SPR EA1N and EA2 PROJECTS

SASES DEADLINE 2 – COMMENTS ON EXQ 1 RESPONSES - 1.9 LAND USE

Interested Party: SASES

0 100 200 Metres

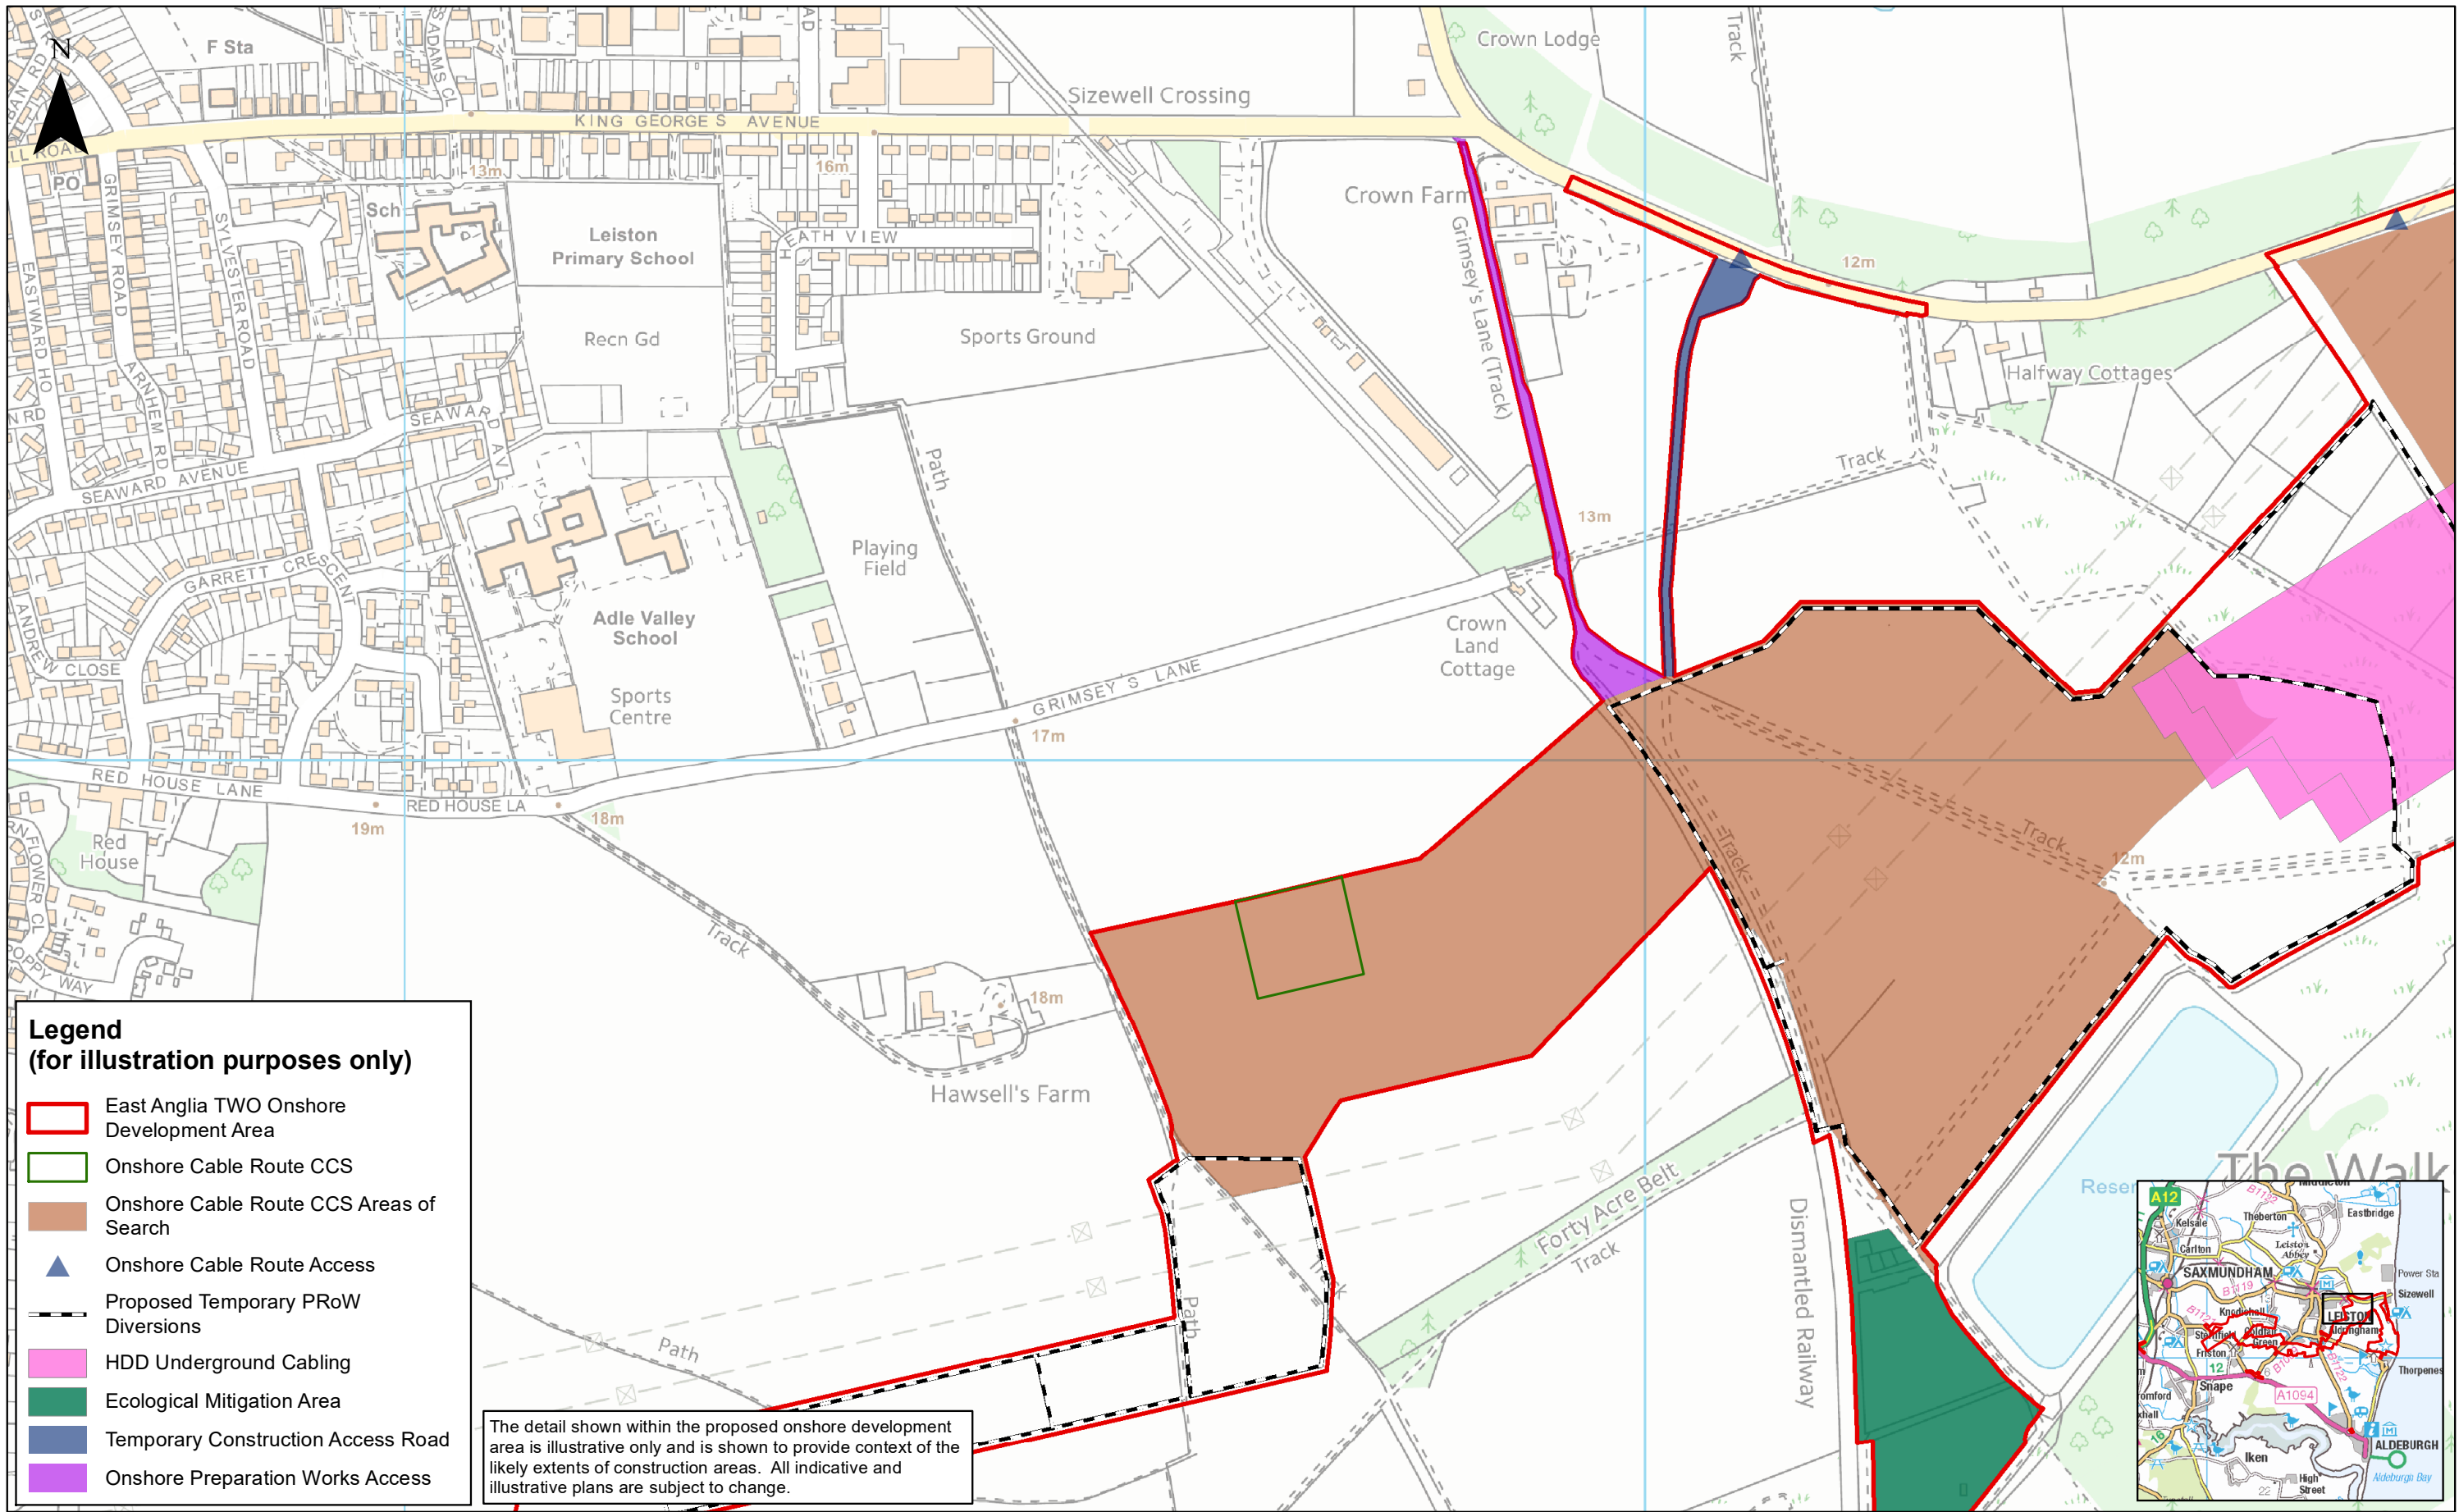
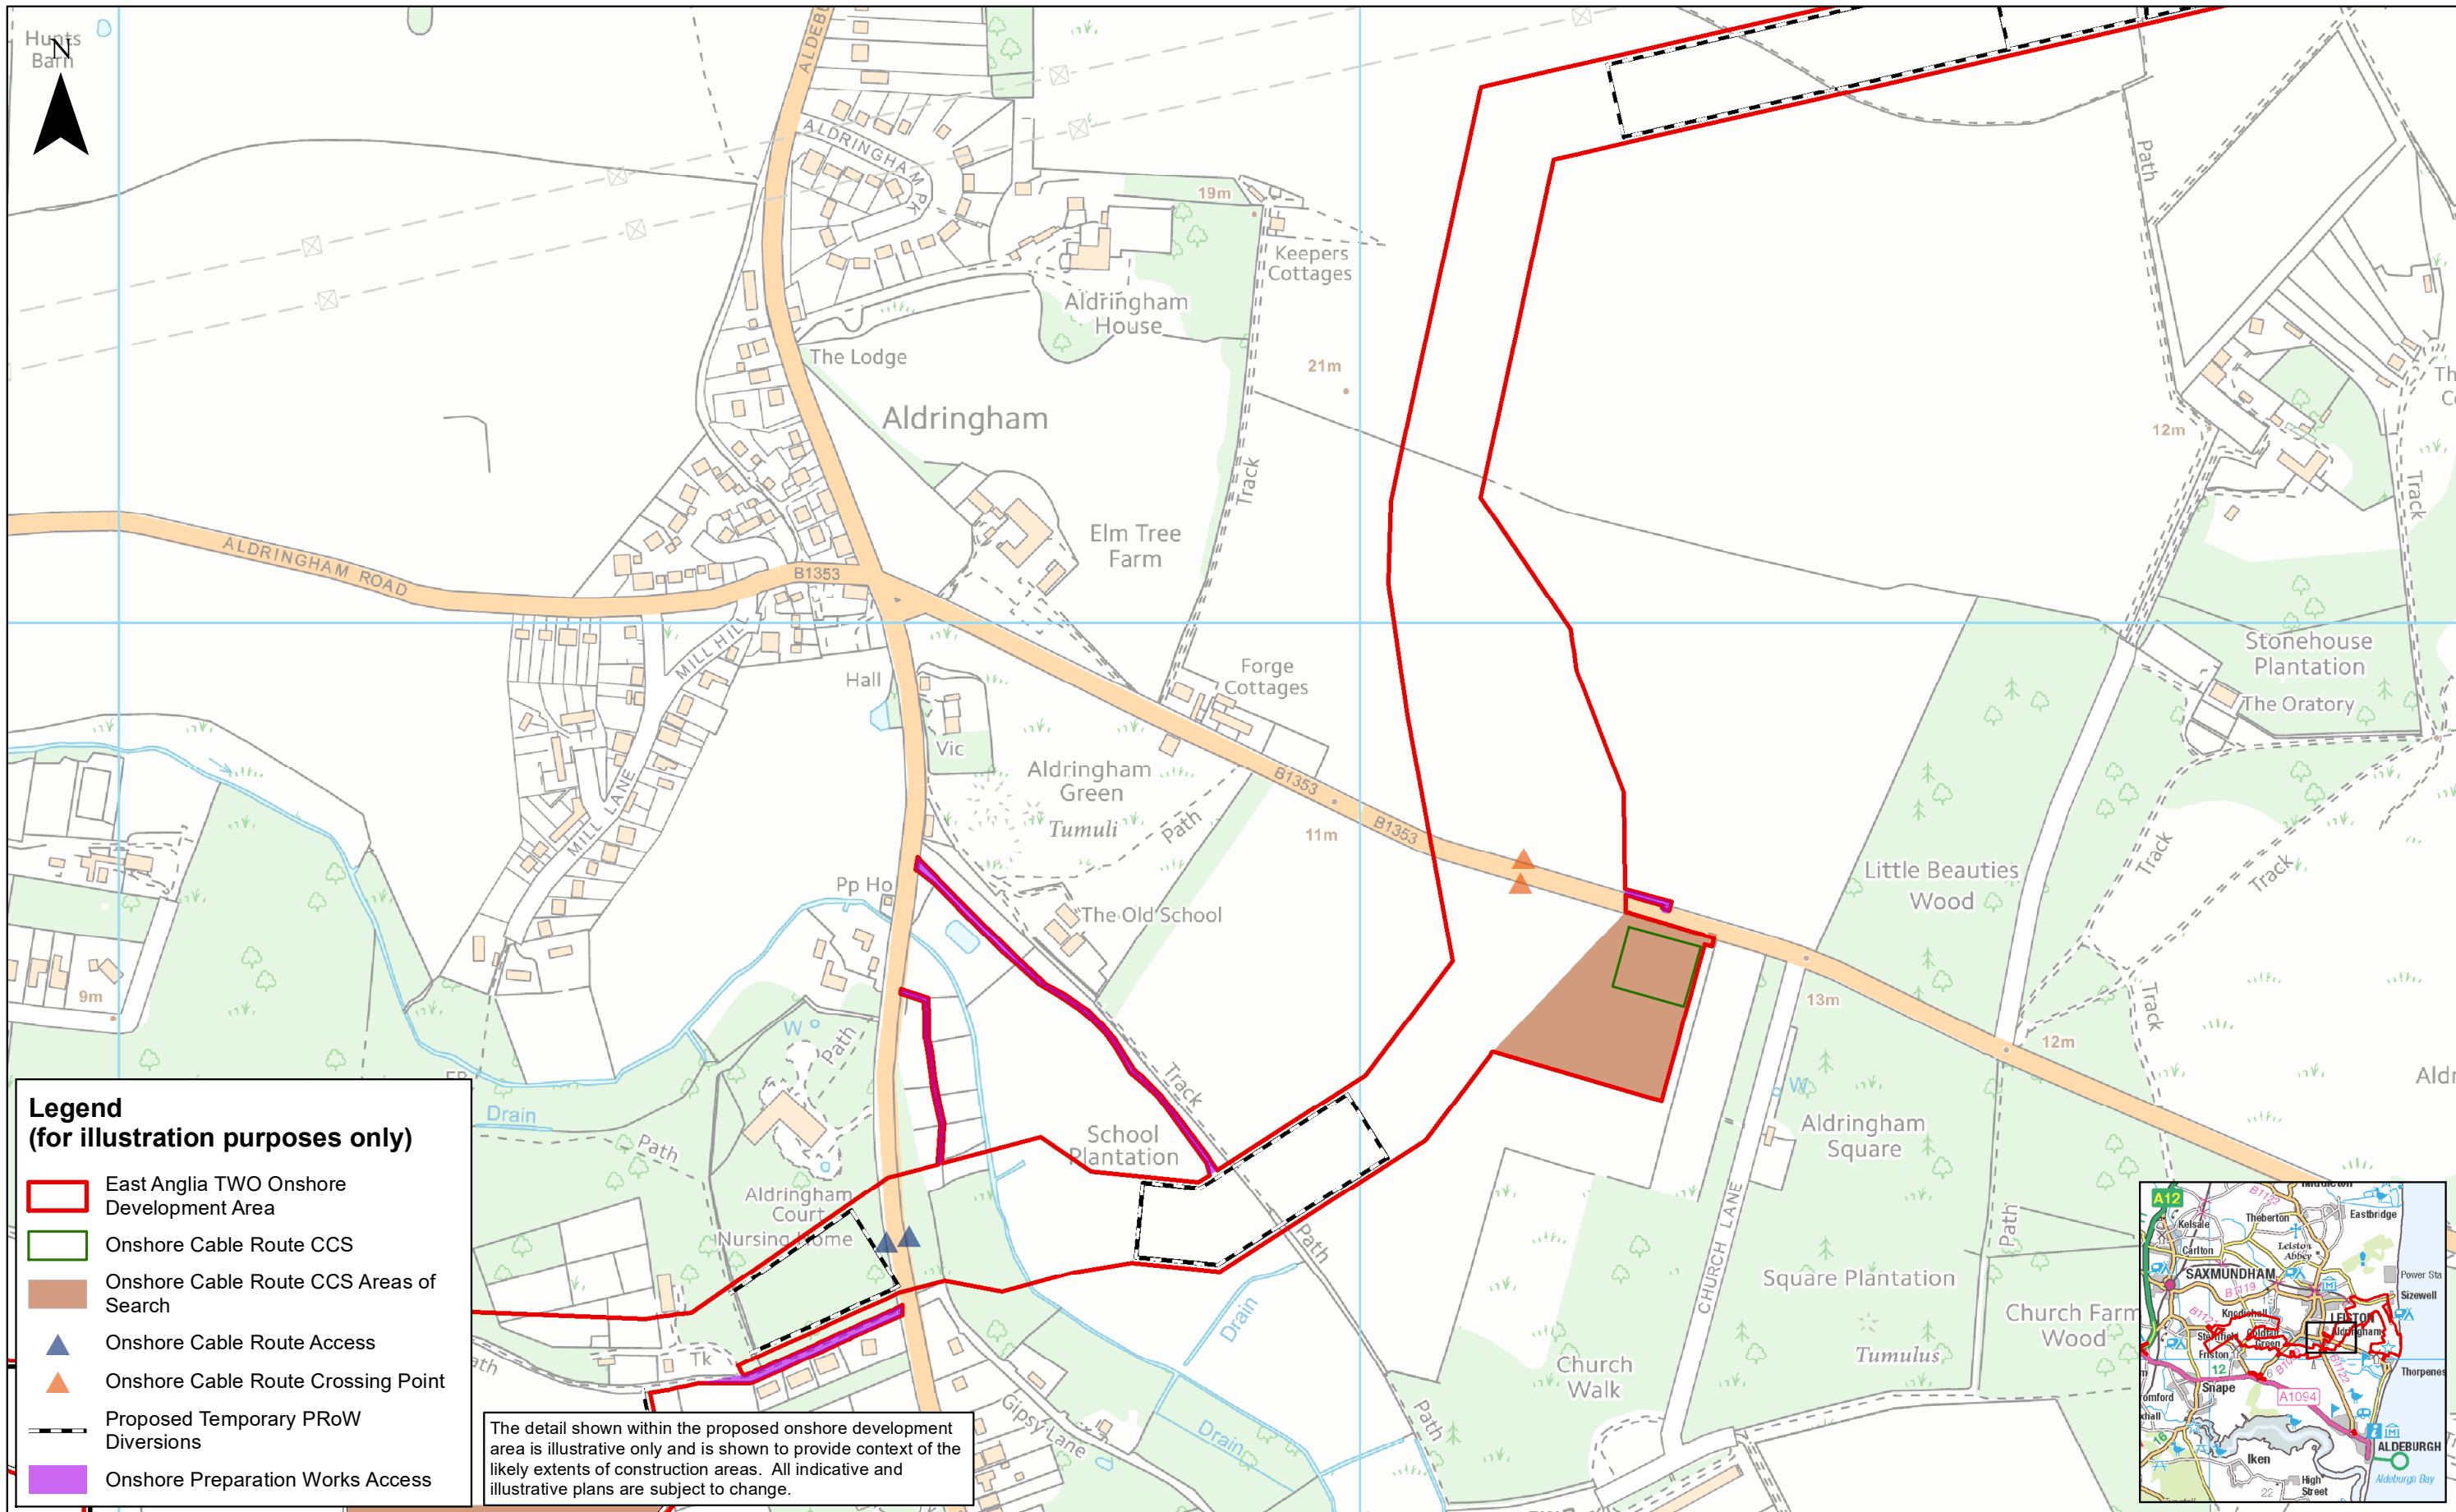
<p>1.9.21 PRoW Strategy</p>	<p>Explain what measures you will take to avoid nuisance and ensure the safety, amenity and quiet enjoyment by those using them in the vicinity of the construction works, with particular reference to the Suffolk Coastal Path</p>	<p>The Applicant has answered this question mainly in relation to the landfall location at Thorpeness.</p>	<p>SASES asks for an explanation of what measures will be taken with regard to the PRoW network on the substation site at Friston during the construction period. Specifically what footpaths will be open and available for use and how safety, amenity and quiet enjoyment can be maintained.</p>
